From: Matthew Kennett
Sent: 17 November 2015 10:43
To: Planning.Responses; Neil Crowther
Subject: RE: Planning Consultation on A/137/15/DOC

Registered: 28-SEP-15
Site Address: West End Nursery Roundstone Lane Angmering BN16 4AX

Description of Works: Application for approval of matters reserved by conditions imposed under A/122/12 relating to condition No. 25 - Contamination

- LEGEND**
- Approximate area of bunds
 - Borehole Location - Jan 2015
 - Hand Auger Location - Jan 2015
 - Borehole Location with installation - Jan 2015
 - ⊠ Trial Pit Location - May 2015
 - Regrading proposed in this area

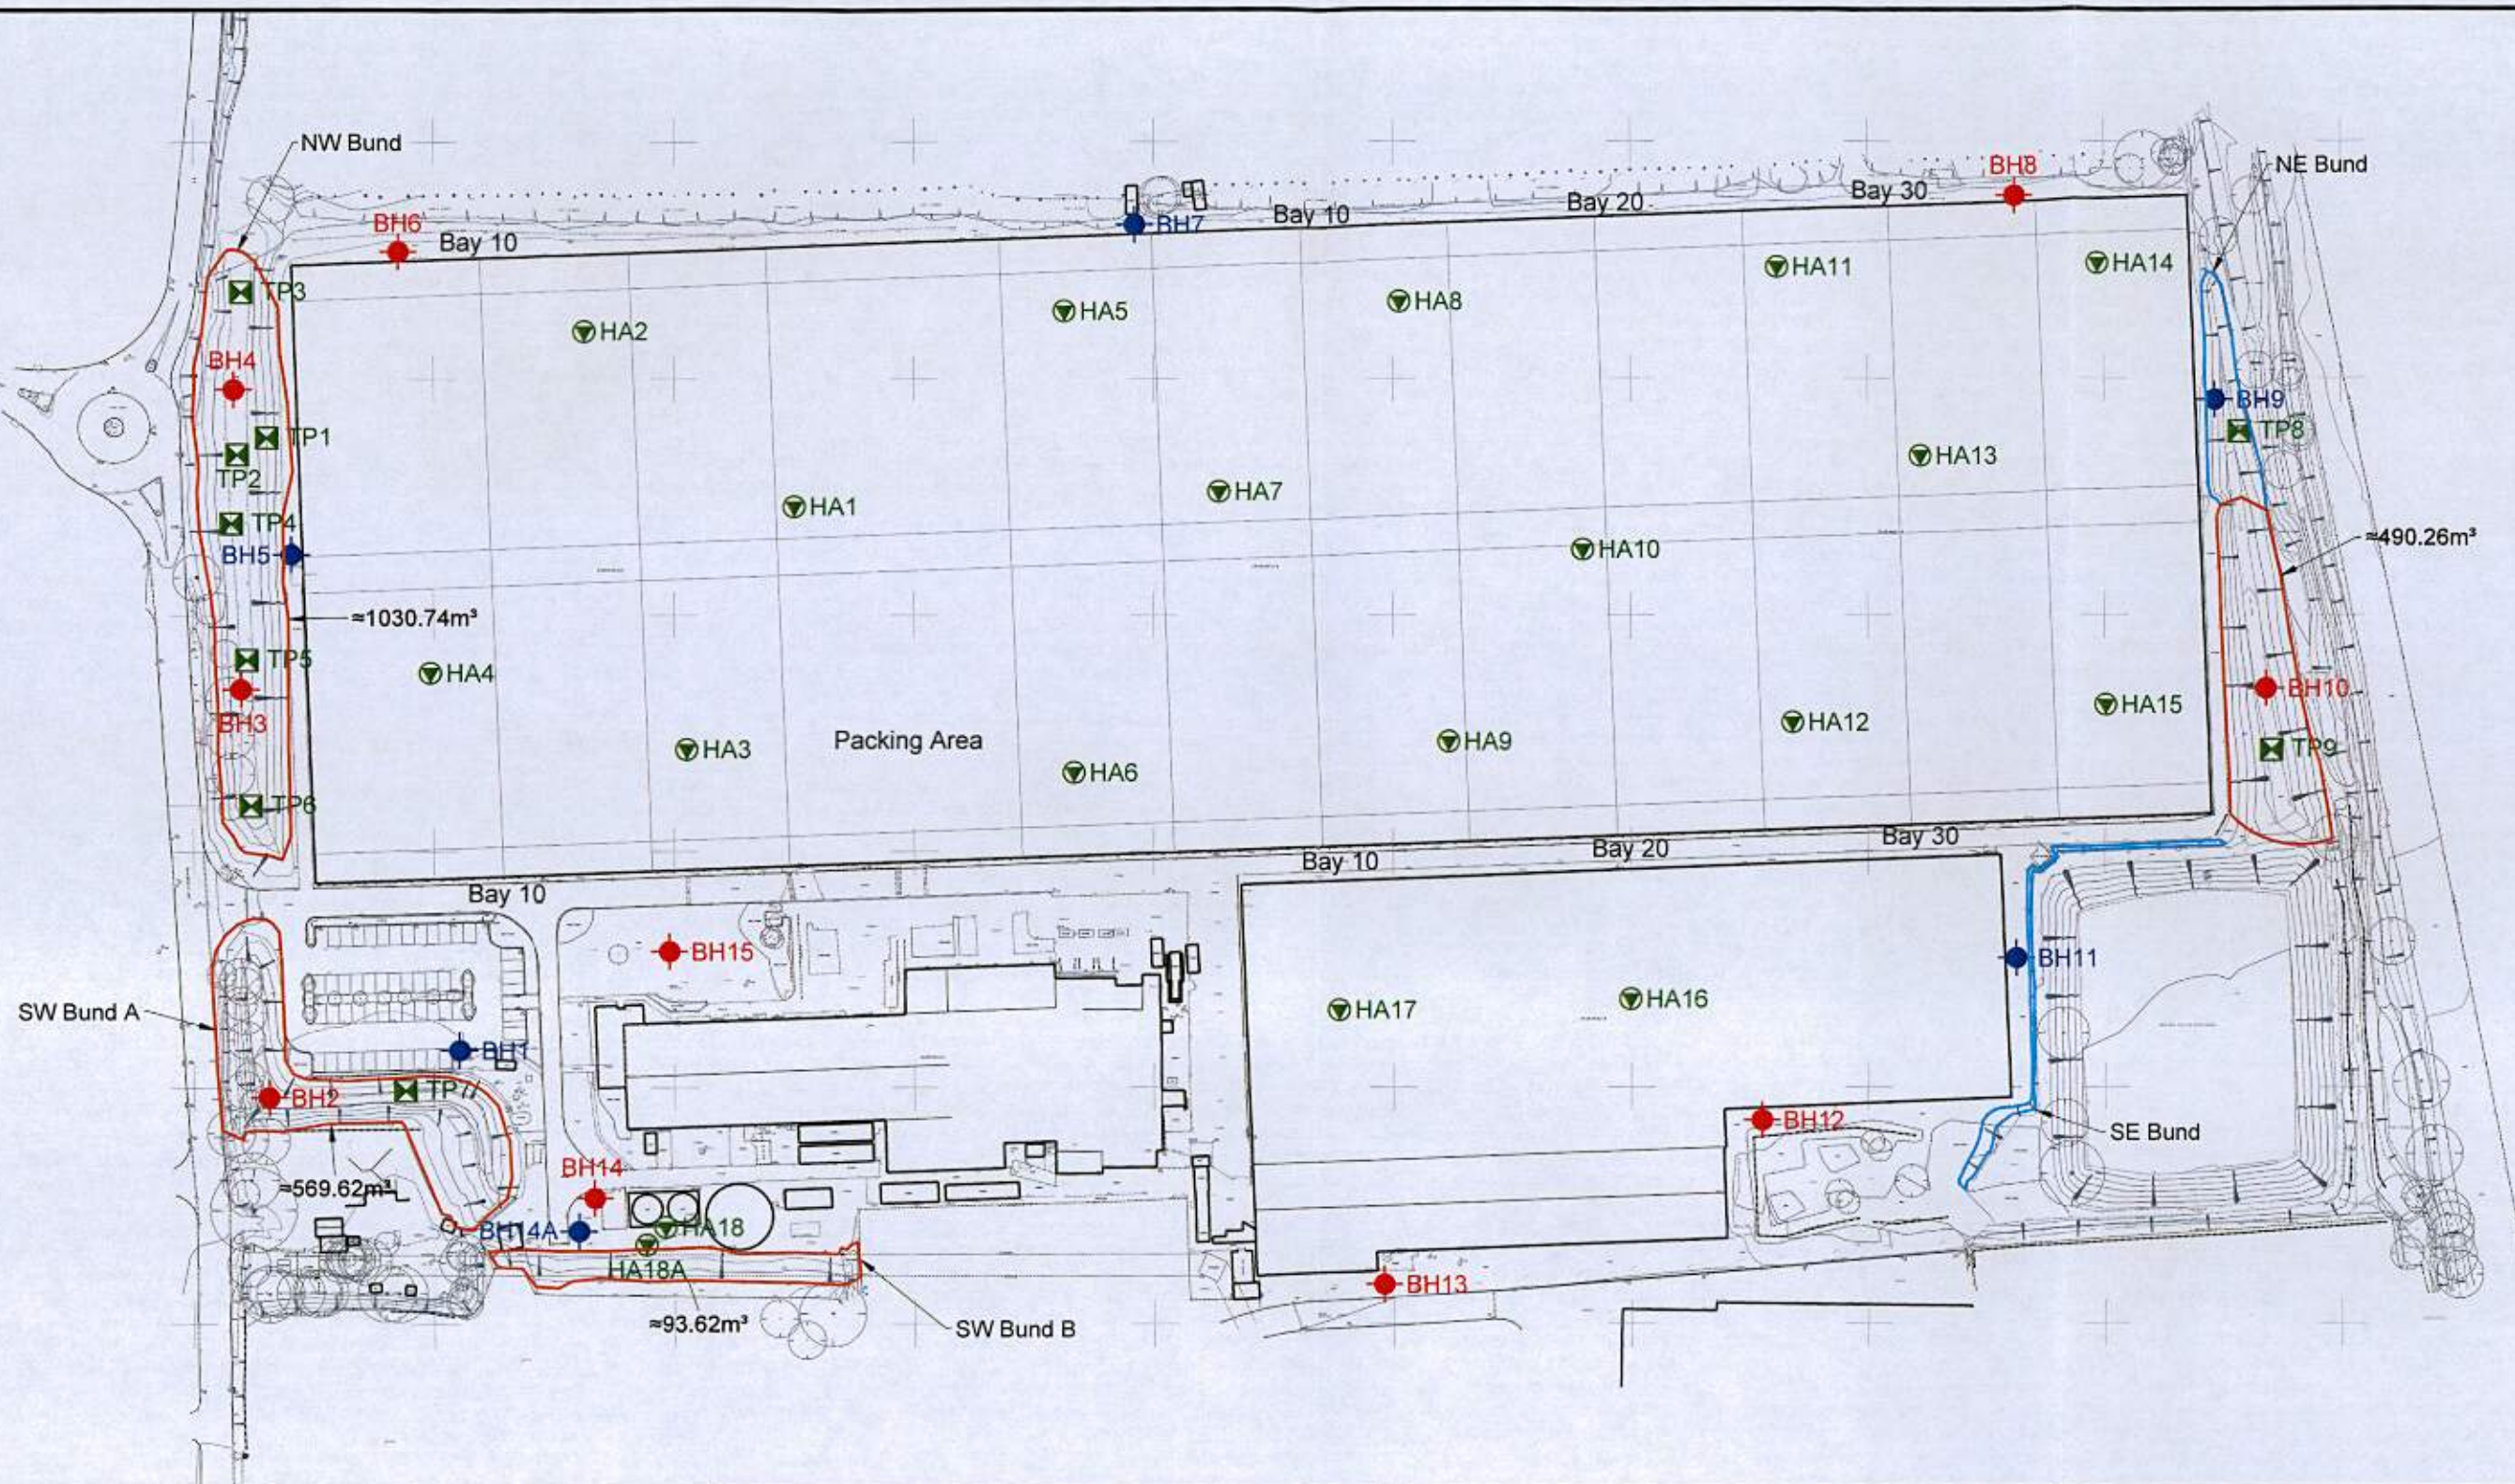
There are plans to relocate bund soils contaminated with asbestos. This could potentially release fibre containing dusts the remediation strategy says care will be taken but does not contain any specifics.
